From: Dan Chamberlain [REDACTED]
Sent: 18 May 2015 09:31
To: Ross Leal
Subject: Re: R/63/15/HH - 18 Sheepfold Avenue, Rustington - Proposed Single Storey Side Extension

Proposed Extension
18 Sheepfold Avenue
Rustington
BN16 3SQ
Scale 1:100 (A3)

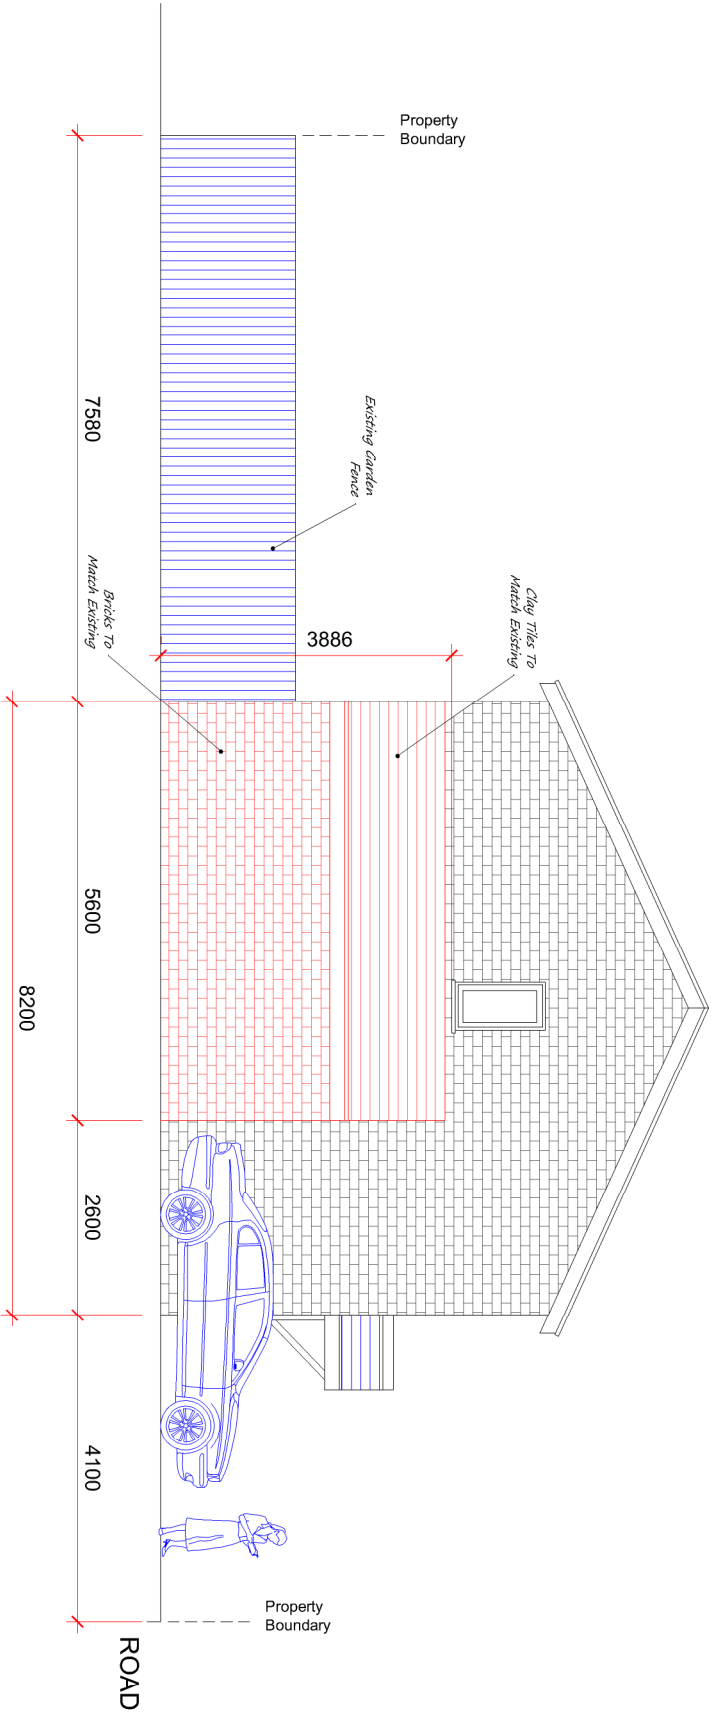
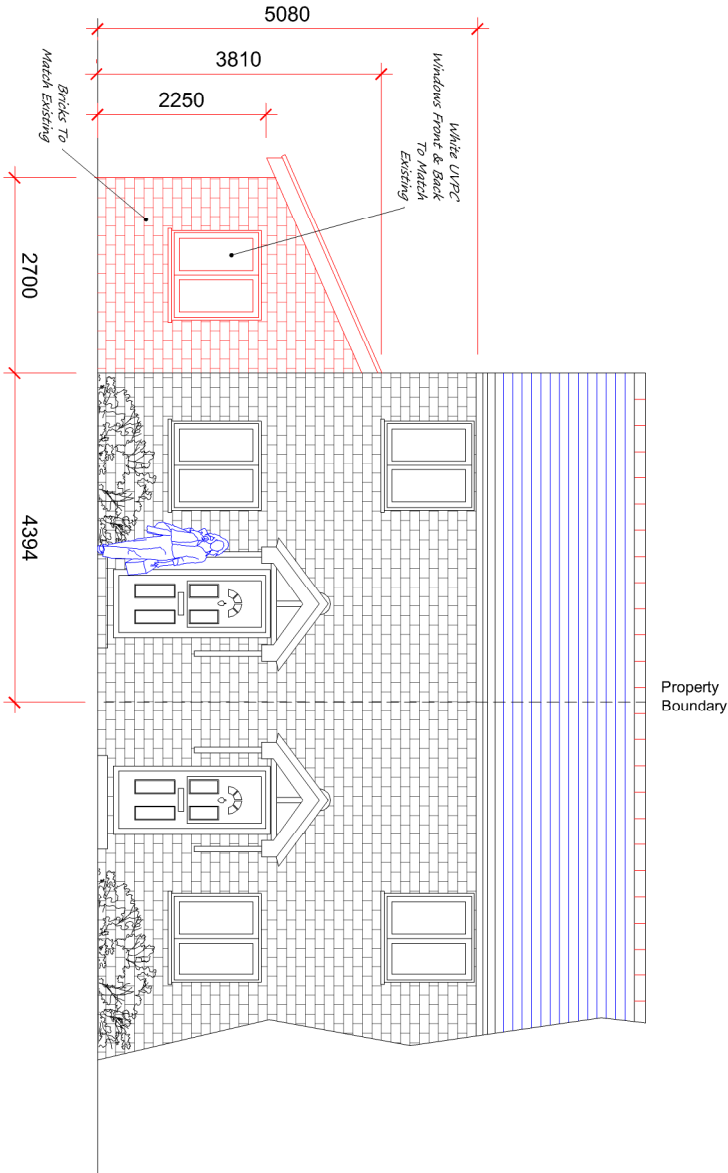
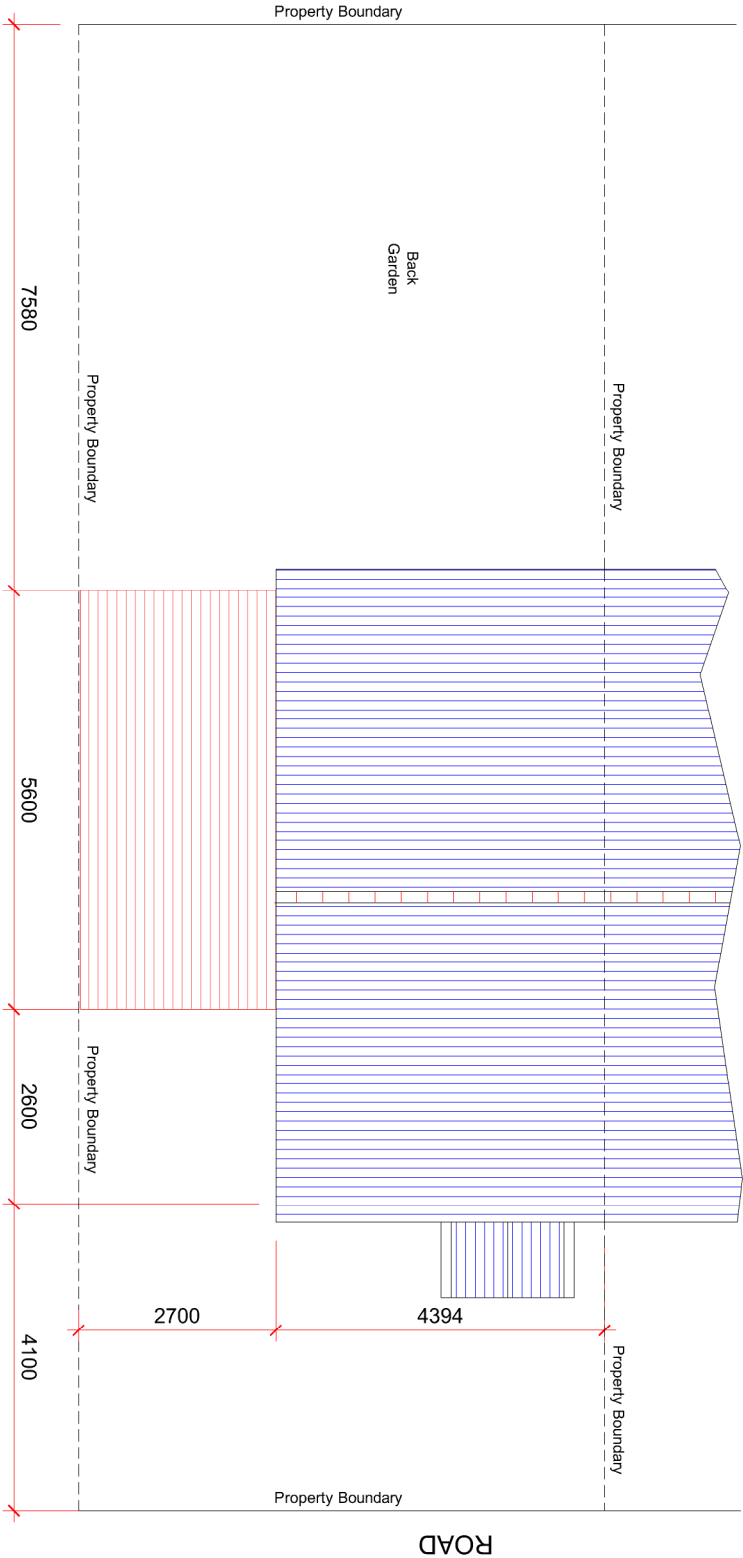
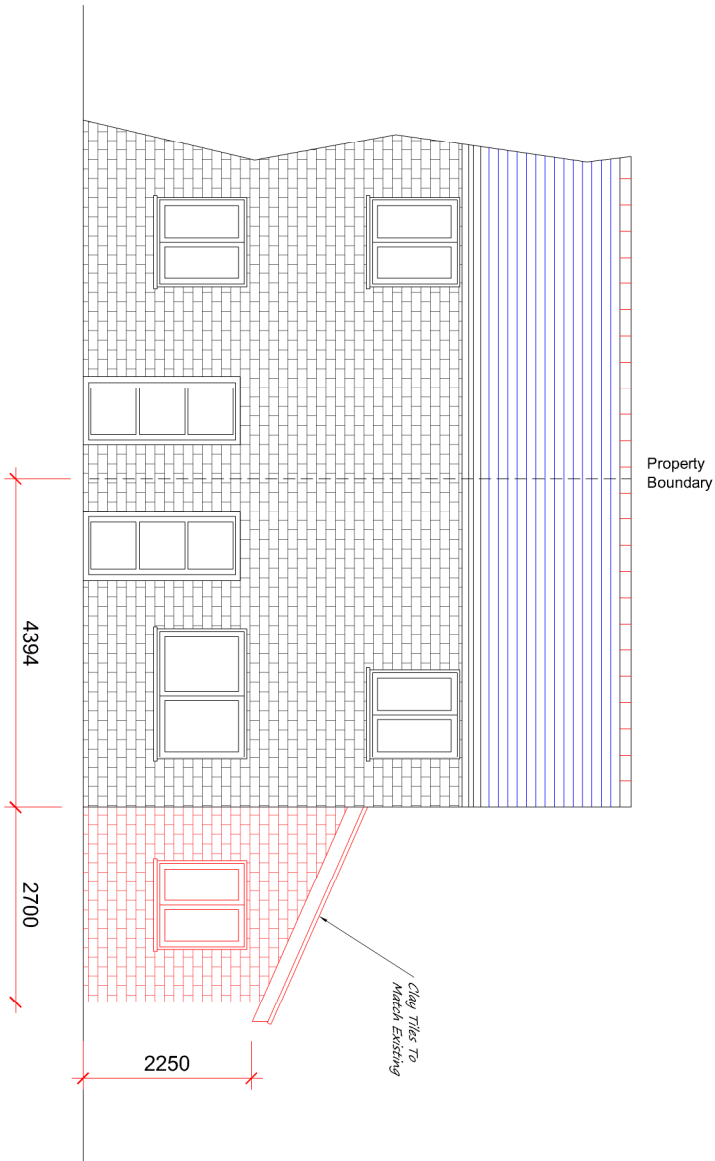
It has been pointed out the soffit, fascia, gutter and part of the roof of the proposed extension will overhang land which you do not own. I have now looked at the drawings in detail and this is correct. Therefore part of the extension overhangs land which you do not own/control and which is not a part of the application site. No notice has been served on the adjoining occupier and therefore your application is invalid, since notice should have been served and the Certificate B served, not Certificate A.

Given that if your neighbour does not agree to the overhang, you will unlikely to be able to erect this extension, it would not be prudent to serve Notice without obtaining that agreement. If it is not possible to obtain agreement, then your scheme will need to be revised.

I have spoken to my builder who had reduced the size of the extension to incorporate the soffit and gutter and the revised plan will be submitted very shortly.
